City of Portland, Maine - Building or Use Permit Application
 389 Congress Street, 04101 Tel: (207) 874-8703, Fax: (207) 874-8716

Permit No: 08-0411	Issue Date:	CBL: 342 B044001
------------------------------	--------------------	----------------------------

Past Use: Single Family Home	Proposed Use: Single Family Home - Add Deck	Permit Fee: \$50.00	Cost of Work: \$3,000.00	CEO District: 5
Proposed Project Description: Add Deck		FIRE DEPT: <input type="checkbox"/> Approved <input type="checkbox"/> Denied	INSPECTION: Use Group: Type	
		Signature:	Signature:	
PEDESTRIAN ACTIVITIES DISTRICT (P.A.D.)				
Action <input type="checkbox"/> Approved <input type="checkbox"/> Approved w/Condition <input type="checkbox"/> Denied				
Signature: Date:

**STAIRS (F.V.)**  
 (See Site Supervisors  
 beginning construction)  
 10" Min. Tread  
 7 3/4" Max Rise  
 6'-8" Min. Head Clearance

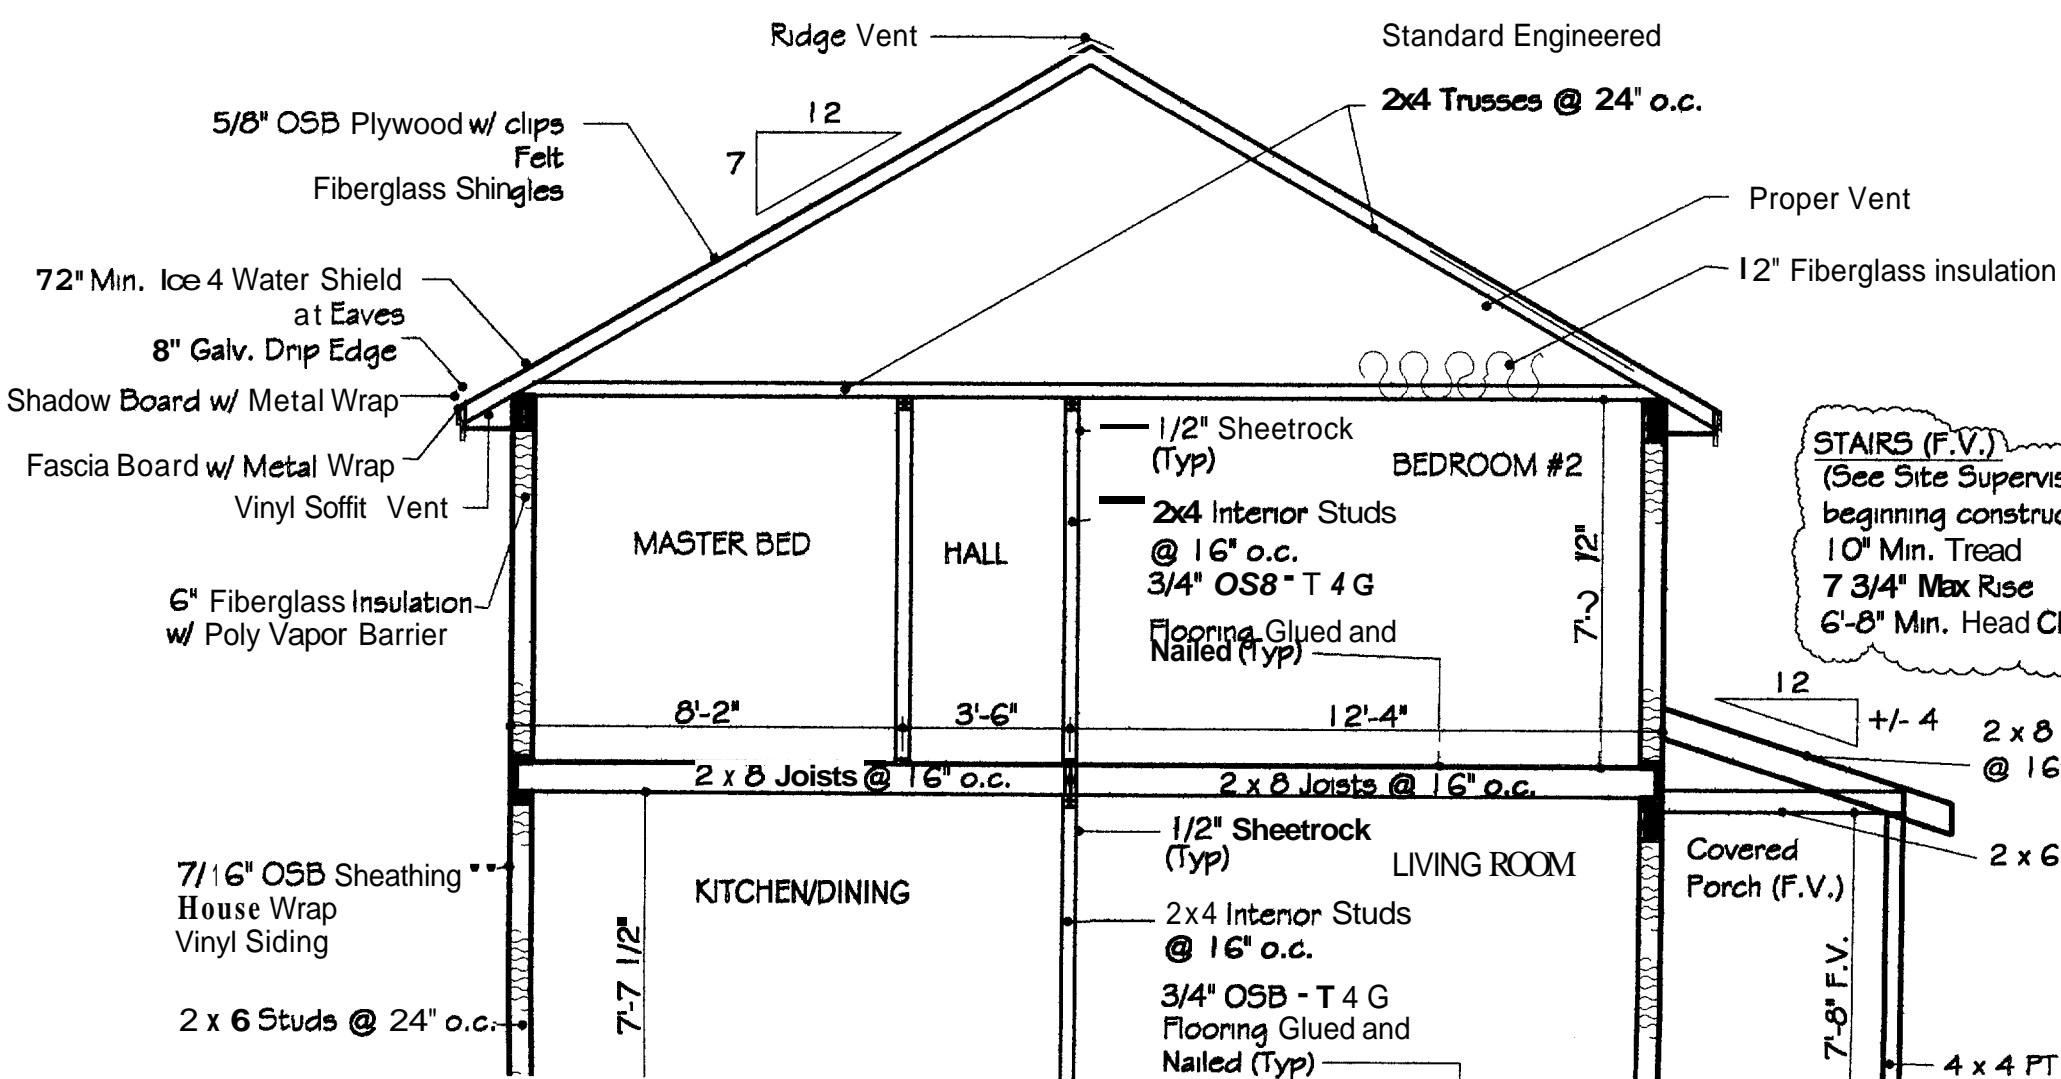
5/1/2008-tmm: need stair detail - left message w/owner

6/23/2008-lmd: Submitted stair details, gave to Tammy with permit app.
